1171BH  
May 2, 2014

**Re: Proposed modification to Salt Ash Sand Extraction Project (MP 07\_0094)**

Figure 5: Proposed acoustic bund design

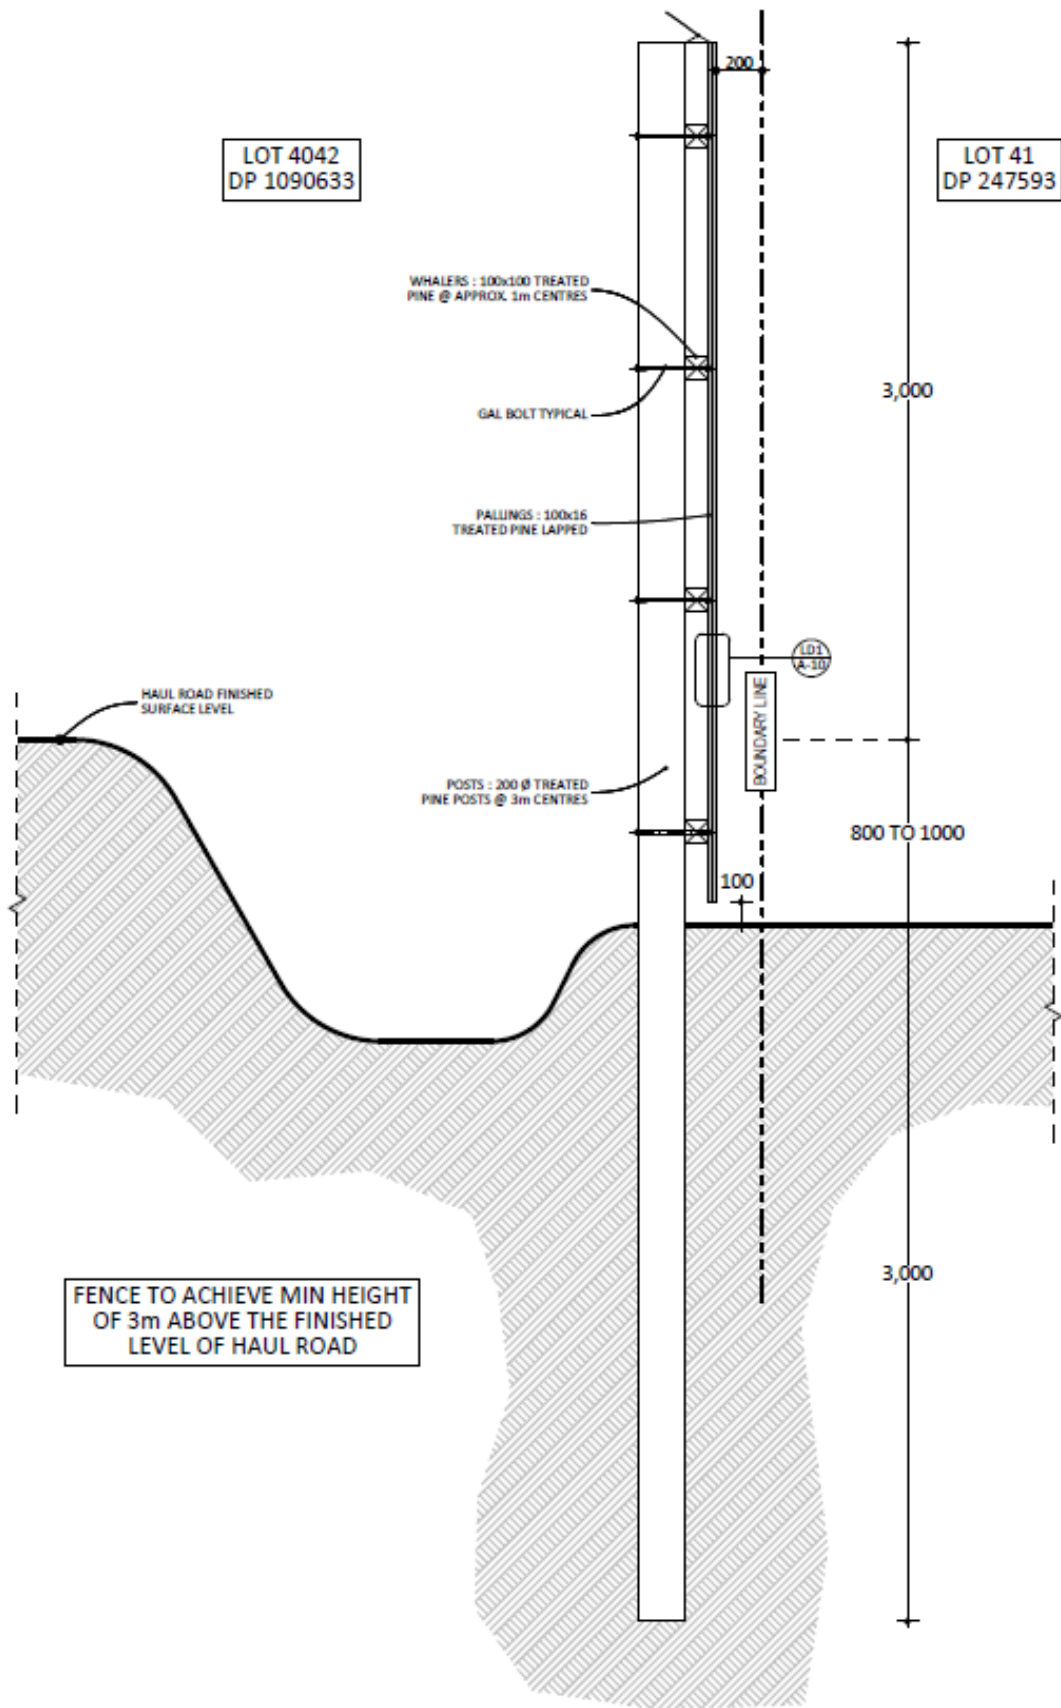
In light of the findings of the *Spectrum Acoustics* report and the current project approval, the company remains committed to providing an acoustic fence along the southern boundary of the haul road. The location of the fence is now, however limited to the common property boundary with Lot 41, DP 247593 which contains receiver JP3. This is detailed in *Figure 2* of the *Spectrum Acoustics* report. As such it is proposed to modify the type of acoustic treatment from a mound and fence to a fence exclusive of the mound. The height of the fence will still be to three (3) metres from the finished surface level of the road. A revised detail is

The amendment to the proposed design of acoustic barrier addressing the southern boundary of the haul road is likely to result in a change in the visual impact of the proposal. It is intended that the mound with fence on top supported by some tree planting will be replaced with a timber 'lapped and capped' fence at the same height. The effectiveness of the barrier for noise mitigation in the 'before' and 'after' scenarios will be unchanged, however the visual impact of the barrier will be increased due to limitations on the type and location of landscaping available as a result of the restrictions imposed by the service provider.
